Consultation Response from KC Conservation and Design
2019/91610 The Barn, The Copse, Scholes Lane, Scholes, Cleckheaton, BD19 6NE
Erection of extensions and alterations (within a Conservation Area)
Date Responded: 29.8.19
Responding Officer: SO
Responding Ref:

GROUND FLOOR PLAN

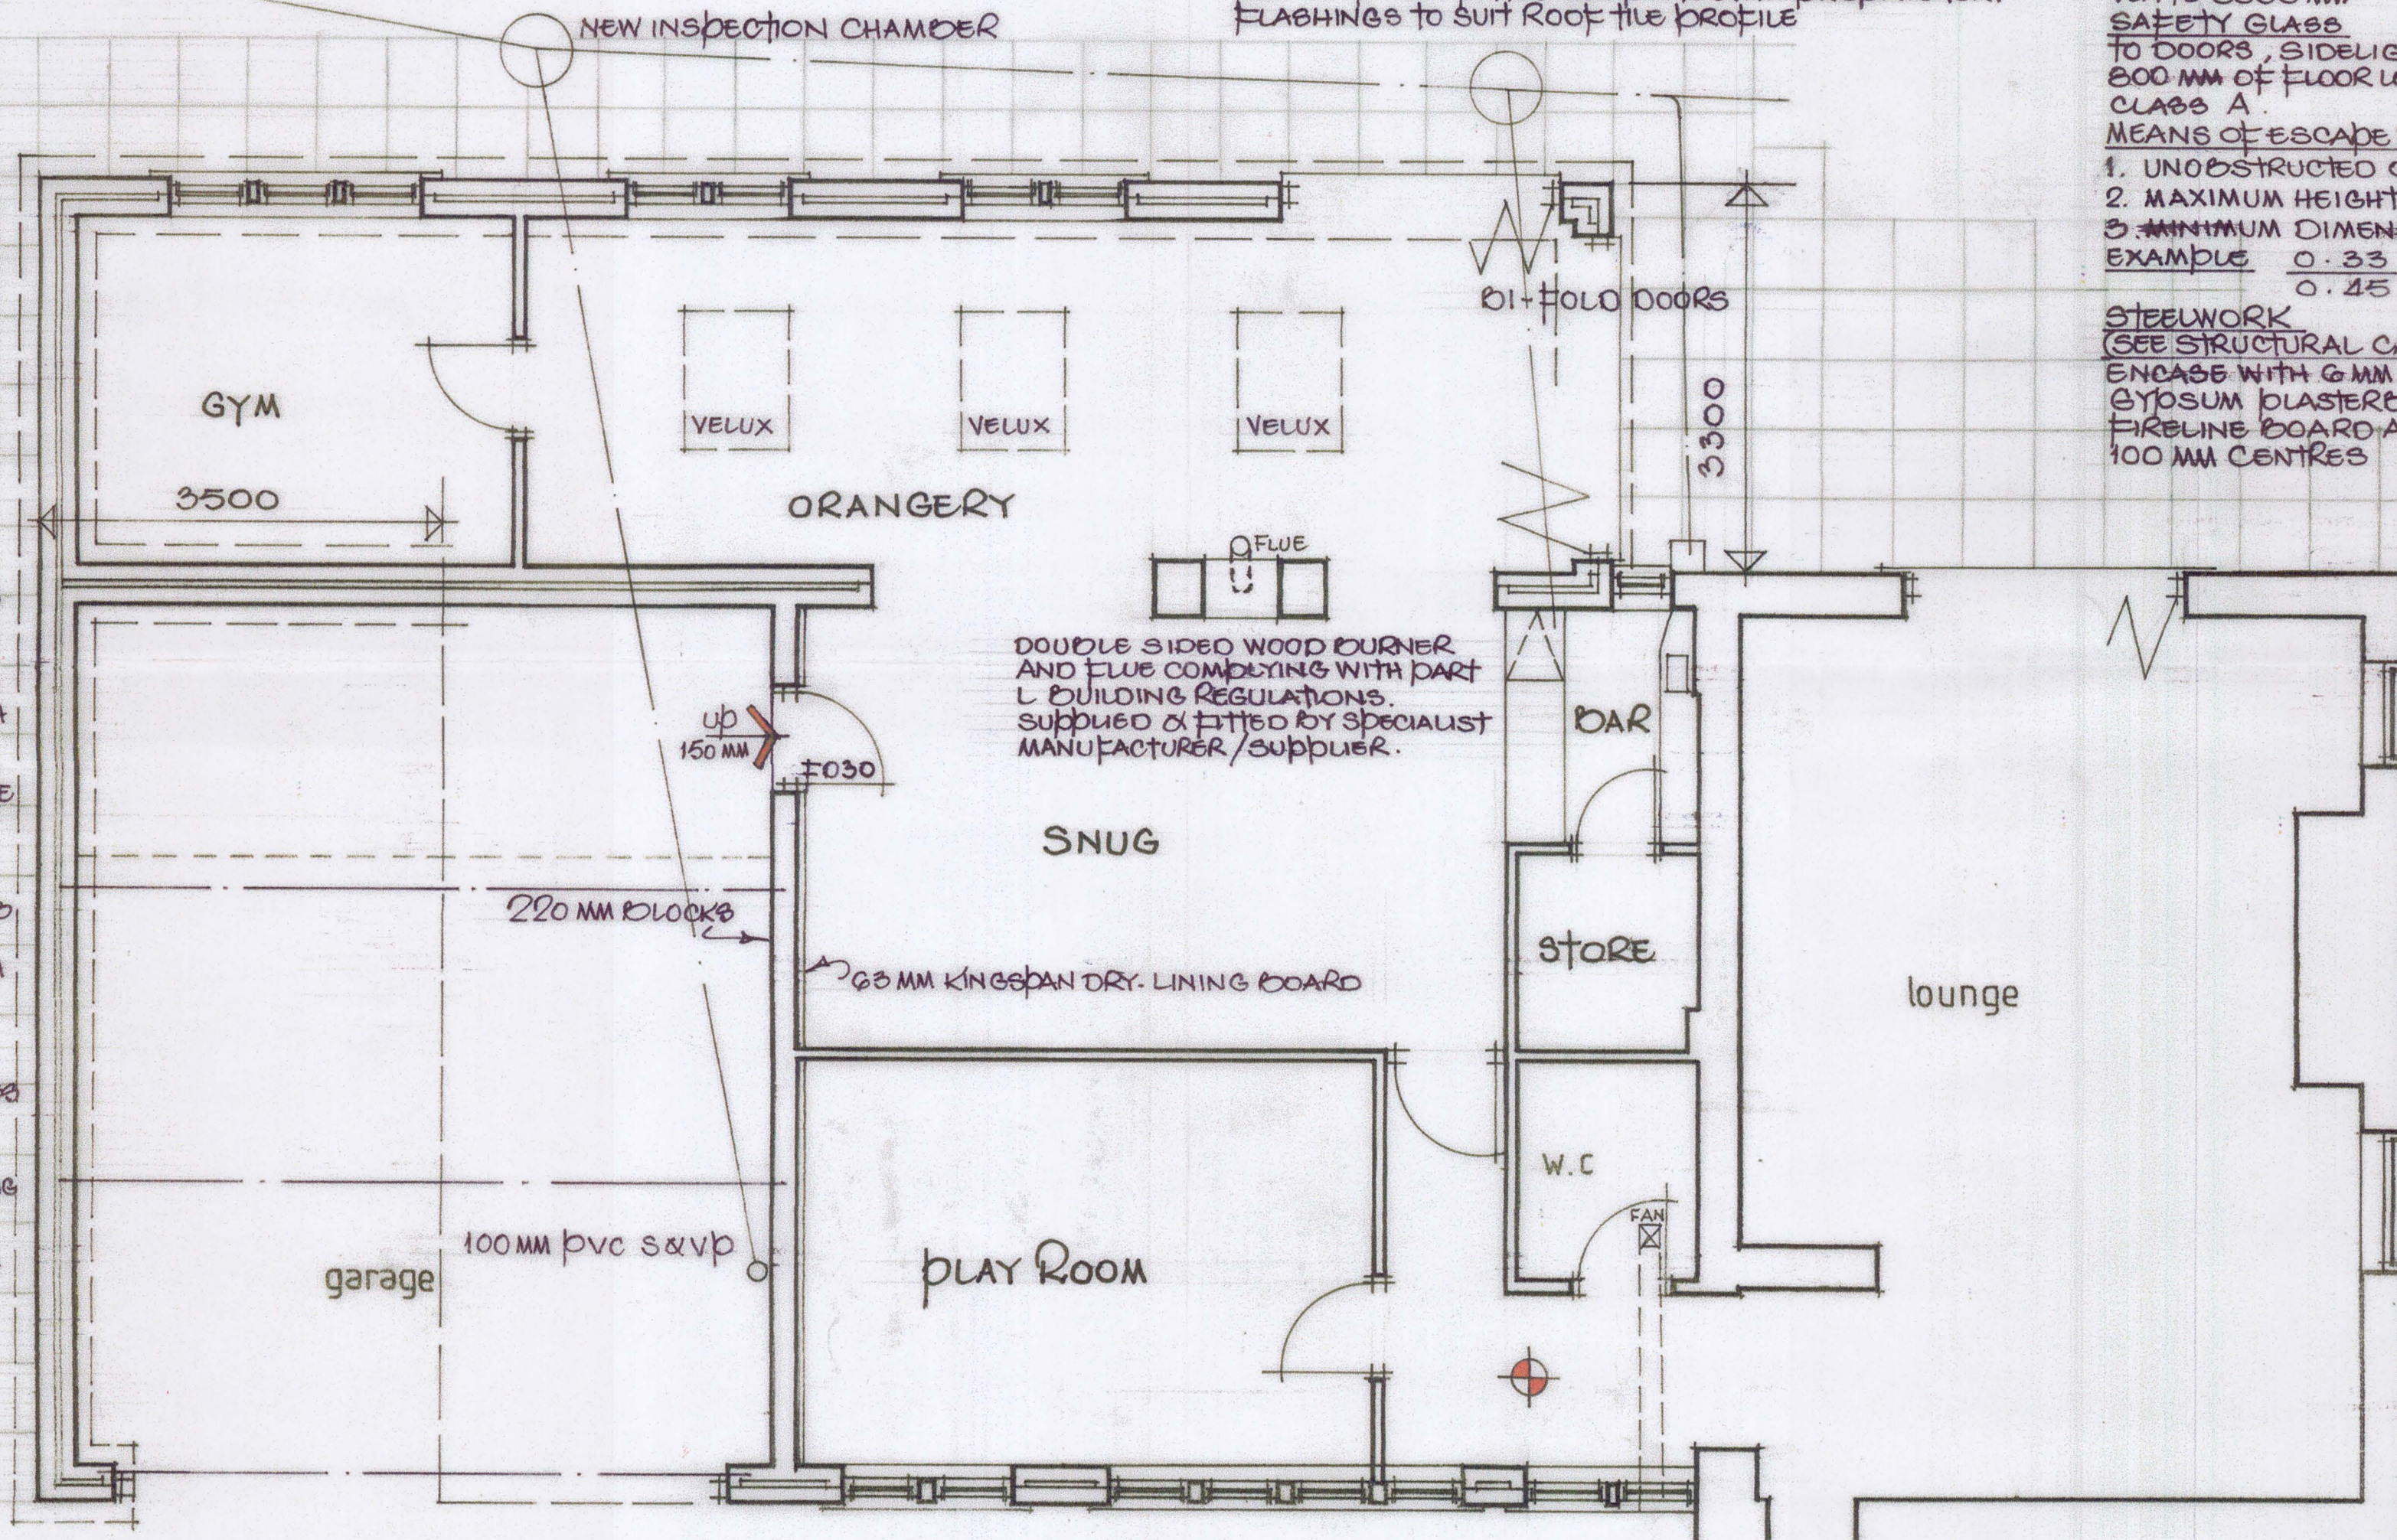
I am concerned about the piecemeal development on this site which has already altered the building substantially. Existing architectural features including the quoin stones and historic openings which still remain contribute to the significance of this building and enable its historic use to be understood, and under this proposal they will be removed with a complete reconfiguration of the external openings.

The existing stable building is subservient to the main barn and I am concerned that the proposed alterations, along with a significant increase in the size of the building, will greatly alter the relationship between the two buildings and erode the character of this former farmstead.

I consider that this proposal will lead to less than substantial harm to the significance of both this undesignated heritage asset and the conservation area itself by substantially altering this historic farm building. The heritage statement does not provide any justification for the extent of changes to this building other than the removal of the dormers installed around 2001 which is welcomed. Consideration has not been given to the historic character of the building and its former use, nor have other options been explored to increase the space within the property without causing harm to its character and significance. I do not consider the application to demonstrate any public benefits to outweigh this harm and piecemeal development does not justify the further erosion of significance and character.

I would suggest that alternative proposals are considered such as the retention of all existing historic openings and architectural details, along with perhaps a detached garage rather than the alteration of the existing structure. As the gable end of the barn has already been extended perhaps this can further extended as an alternative to the proposal to reduce the impact on the historic structure.

FIRST FLOOR PLAN

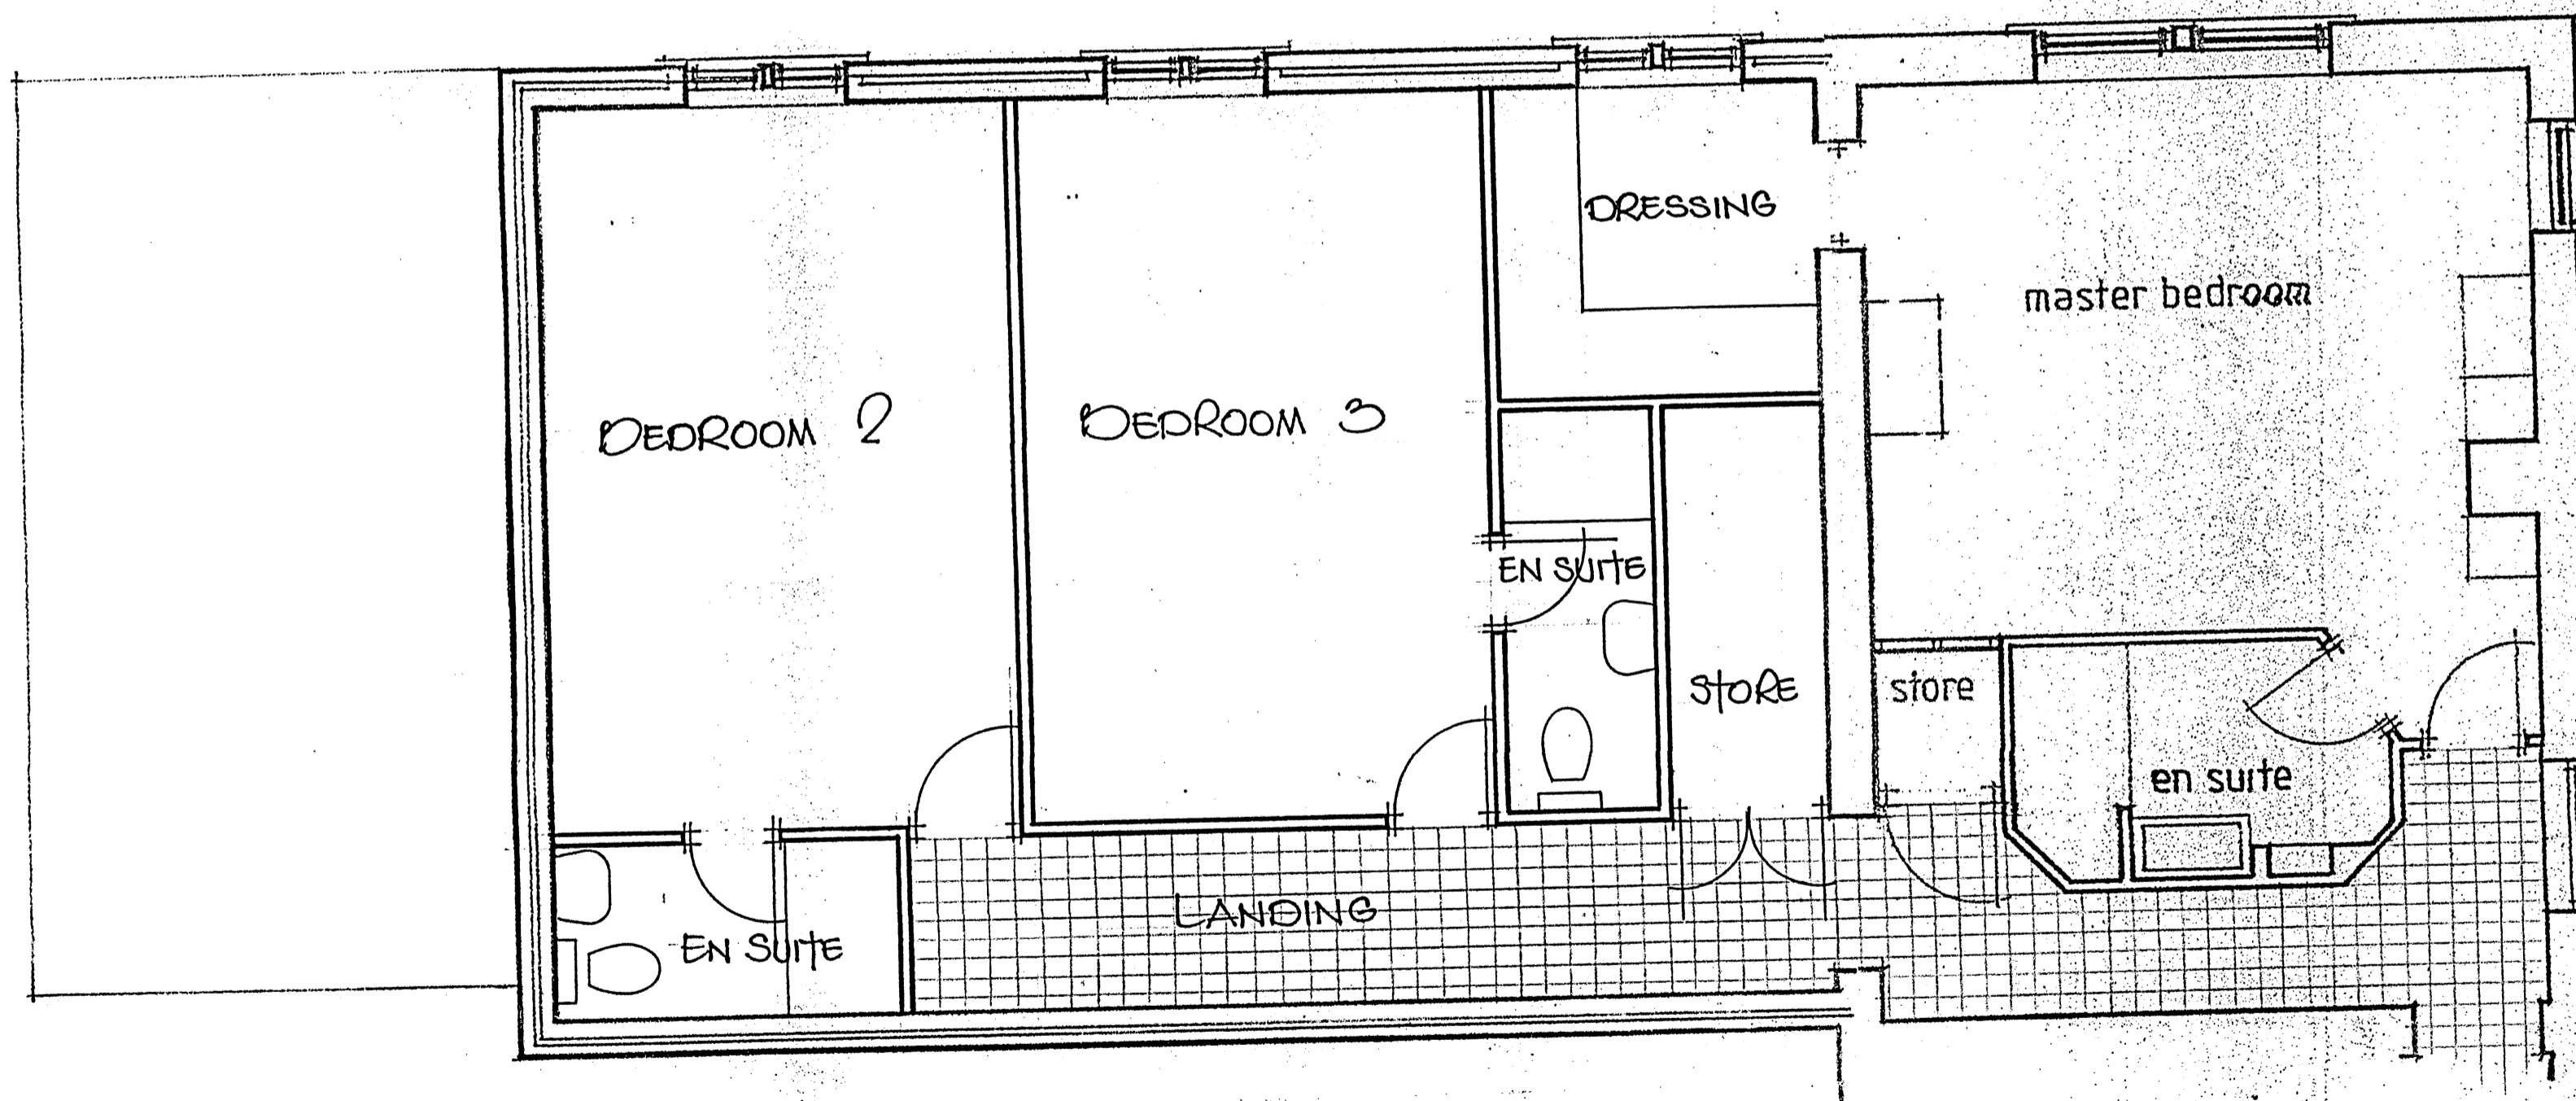
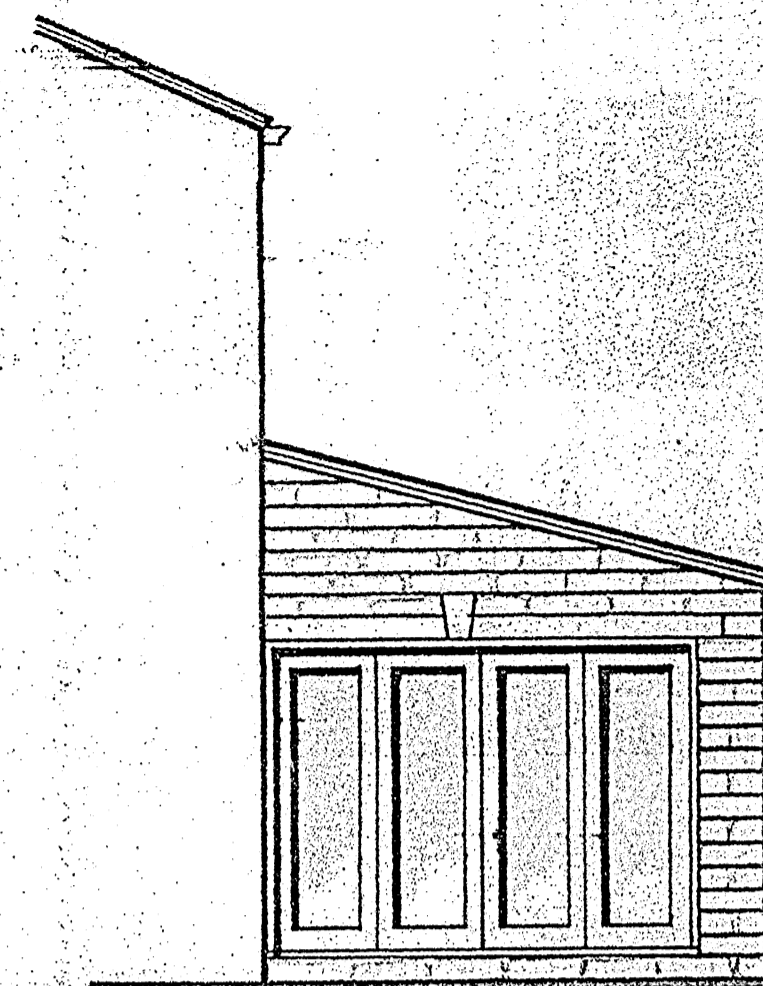
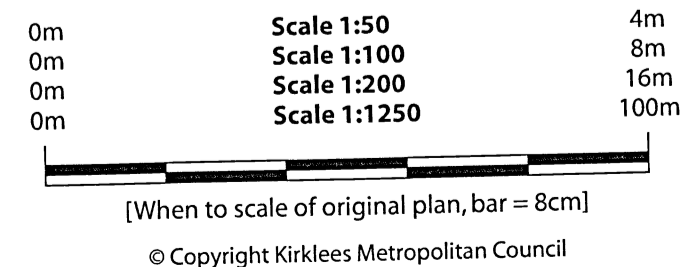
The proposal is to raise the height of the roof of the former stable to create a first floor extension, with a ridge the same height as the main building and earlier extension. In addition to this, the proposal is to increase the length of the former stable and construct a single storey mono-pitch orangery extension along the west elevation of this building. All existing external openings will be removed and replaced with new casement windows with stone surrounds and mullions, reminiscent of a terrace of weaver's cottages. The proposed plan shows cavity wall construction throughout the former stable building which suggests that it will be demolished and a new structure built.
